**Planning Department
Transportation Development Services**

November 2, 2015

Re: GAHP Casa Feliz, Buildings A,B,C,D,E,F,G,H, I, J,K, & L
441 Espanola SE
Traffic Circulation Layout
Engineer's/Architect's Stamp dated 10-16-15 (L19-D073B) **A-I**

OVERALL TRAFFIC
CIRCULATION LAYOUT

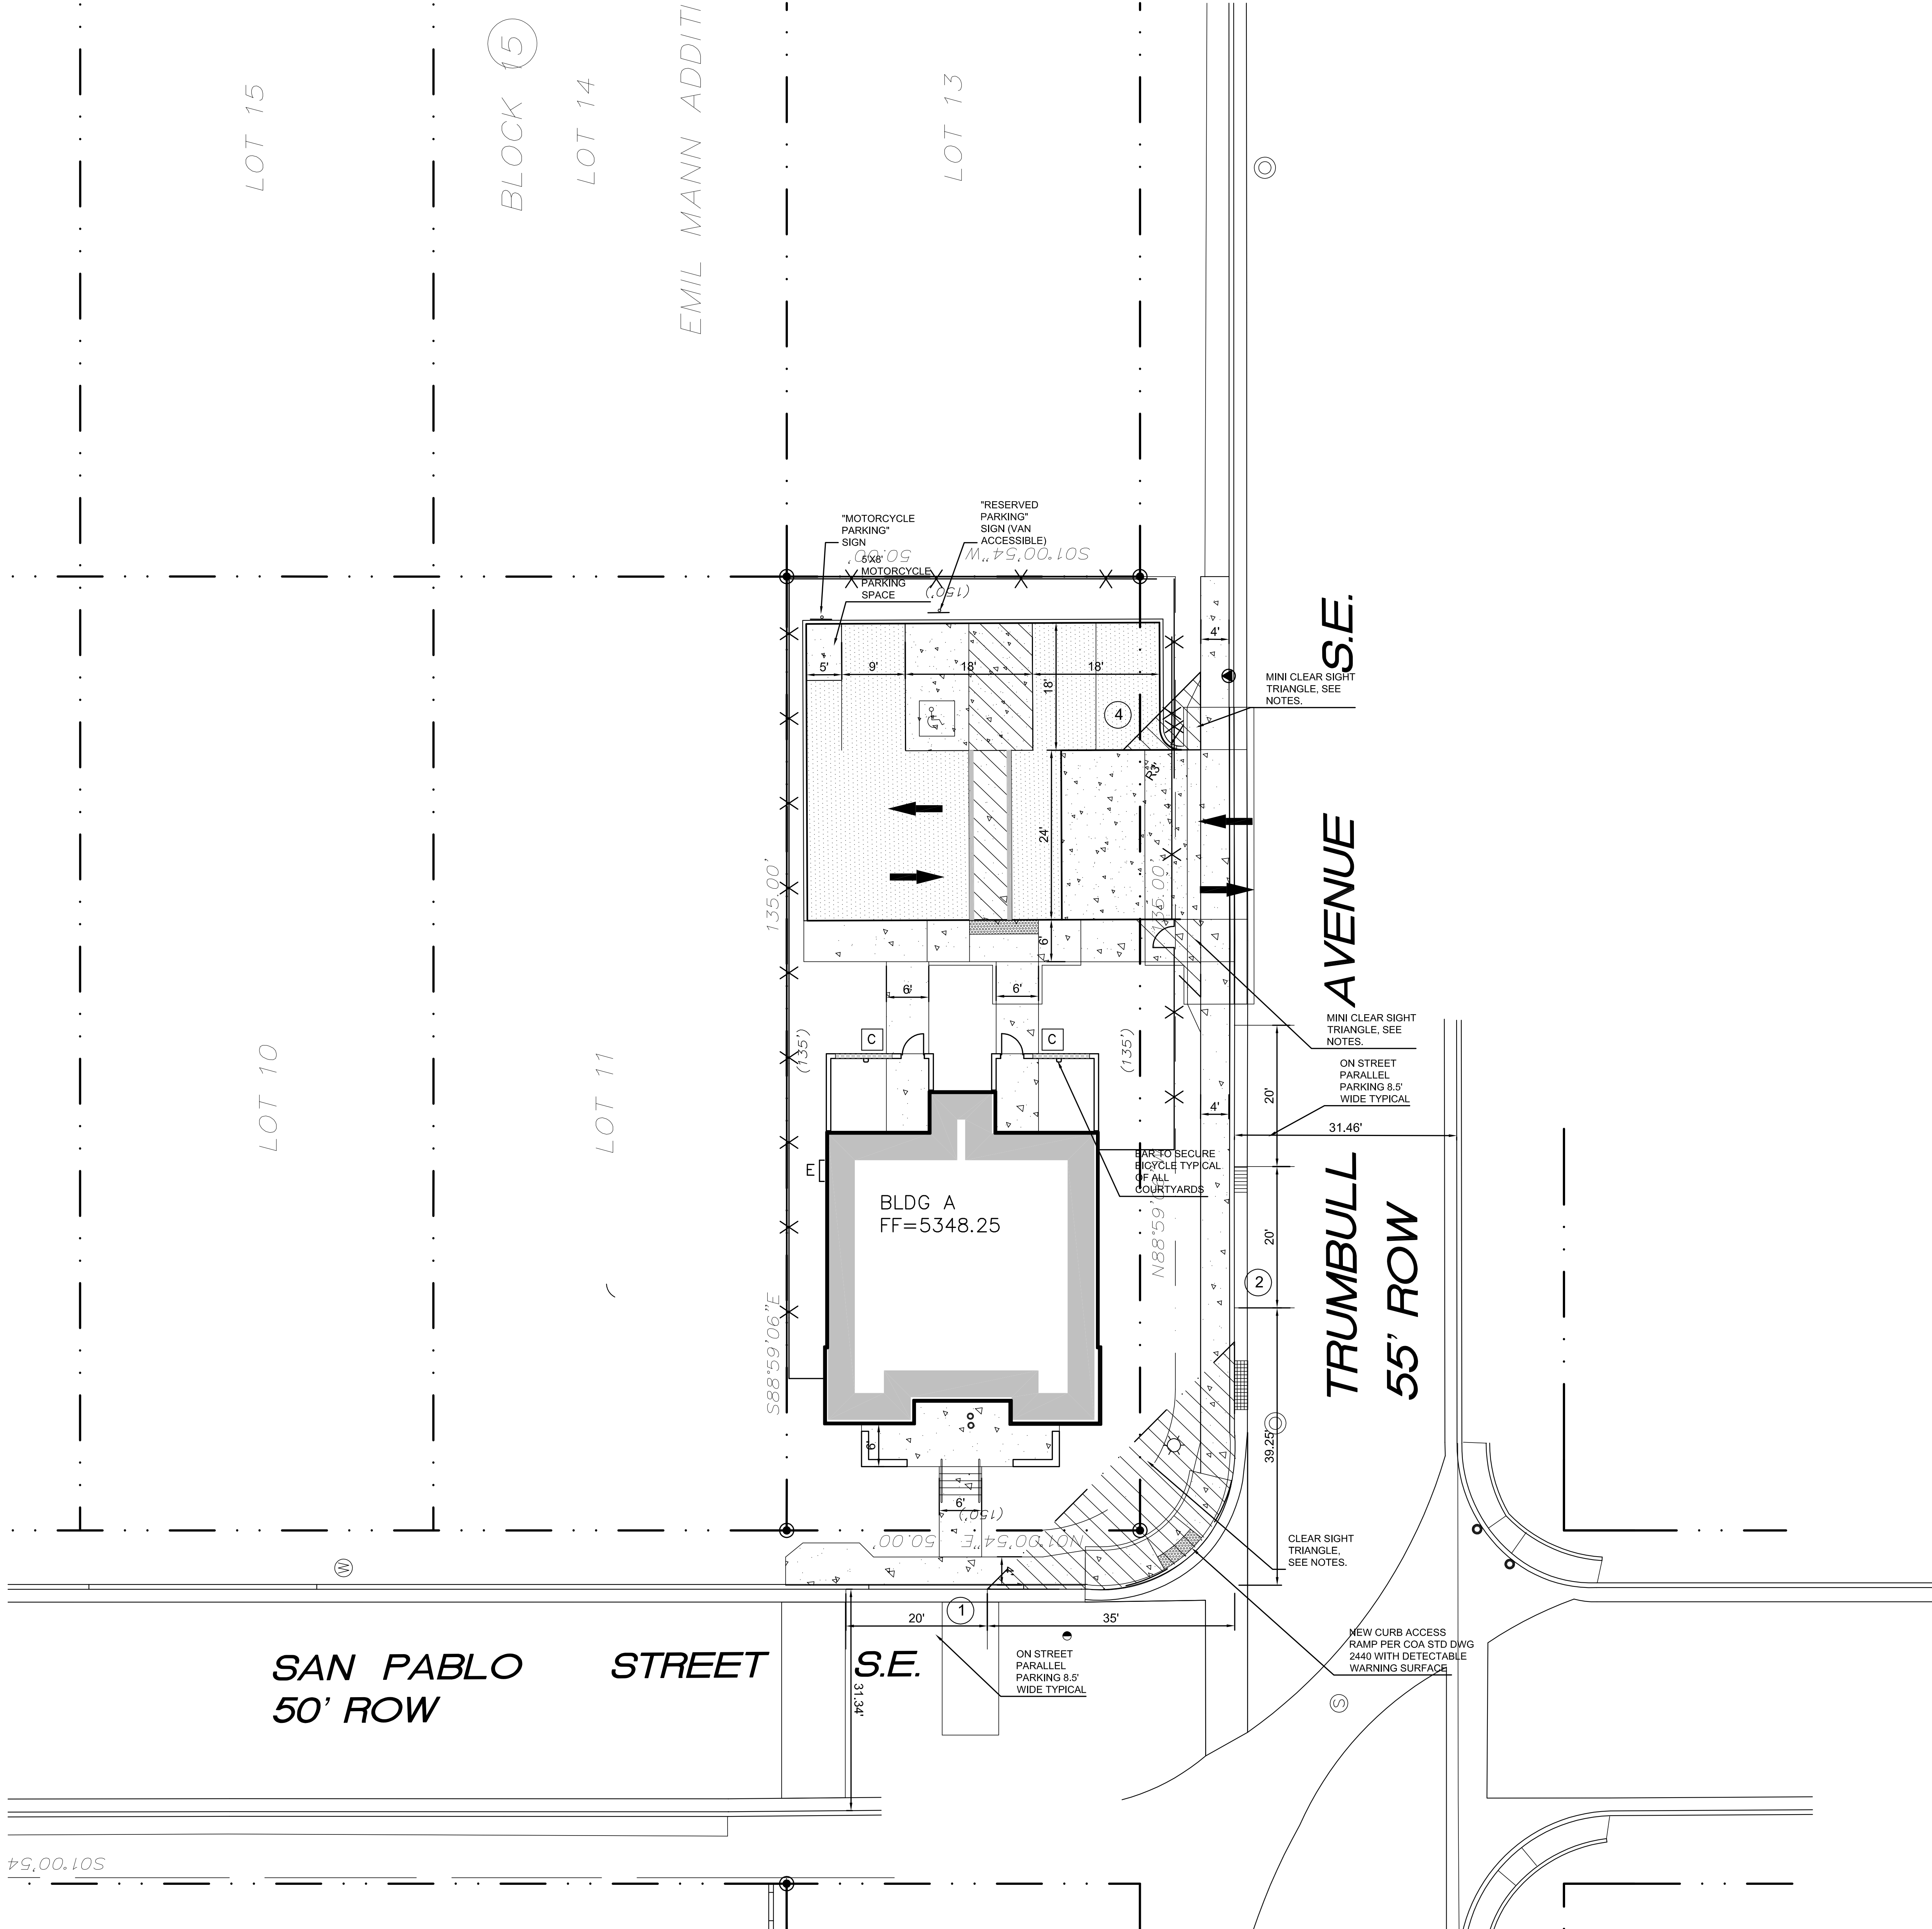
1. Please show a vicinity map showing the location of the development in relation to streets and well known landmarks.
2. List the number of parking spaces required by the zoning code as well as the proposed number of parking spaces.

3. Clarify the extents of the current phase.
4. Please dimension all sidewalks, curbs, drive pads, walls and anything that influences the parking and circulation onto the multiple project sites.

5. Identify all existing access easements and rights of way with dimensions.
6. Identify the right of way width, medians, curb cuts, and street widths on all arterial streets and intersections.

7. Provide detail of ADA ramps with truncated domes at the right of way sidewalks, drive pads and drive pad crossings.
8. The ADA accessible parking sign must have the required language per 66-7-352.4C NMSA 1978 **"Violators Are Subject to a Fine and/or Towing."** Please call out this detail on the drawing.

9. The ADA access aisle shall have the words **"NO PARKING"** in capital letters, each of which shall be at least one foot high and at least two inches wide, placed at the rear of the parking space so as to be close to where an adjacent vehicle's rear tire would be placed. (66-1-4.1.B NMSA 1978)

10. Show all drive aisle widths and radii.

11. Per the DPM, a 6 ft. wide ADA accessible pedestrian pathway is required from the public sidewalk to the building entrances. Please clearly show this pathway and provide details for all project sites.

12. Per the DPM, a 6 ft. wide ADA accessible pedestrian pathway is required from the HC parking stall access aisles to the building entrances. Please clearly show this pathway from the ADA parking spaces at all project sites.

13. Per DPM, there must be a 24 ft. drive isle width between parking spaces and abutting parking spaces or pedestrian pathways. Please show this detail for all project sites.

14. Provide a min 6" or max 8" high concrete barrier curb or other acceptable barrier between landscaping and parking areas and/or drive aisles. Please call out this detail.

15. Service vehicle and/or refuse vehicle maneuvering must be contained on-site; provide a copy of refuse approval.
16. It is not apparent what type of pavement surface is being proposed. A hard driving surface will be required as part of this proposed project for parking area and drive aisles.

17. Please provide a sight distance exhibit (see the *Development Process Manual, Chapter 23, Section 3, Part D.5 Intersection Sight Distance*). Please show the Mini Clear Sight Triangle detail for curb cut entrances/exits off of arterial streets;

18. Please add the following note to the clear sight triangle: "Landscaping and signage will not interfere with clear sight requirements. Therefore, signs, walls, trees, and shrubbery between 3 and 8 feet tall (as measured from the gutter pan) will not be acceptable in this area."
19. Unused curb cuts must be replaced with sidewalk and curb & gutter. A build note must be provided referring to the appropriate City Standard drawing.
20. Please include two copies of the traffic circulation layout at the next submittal.
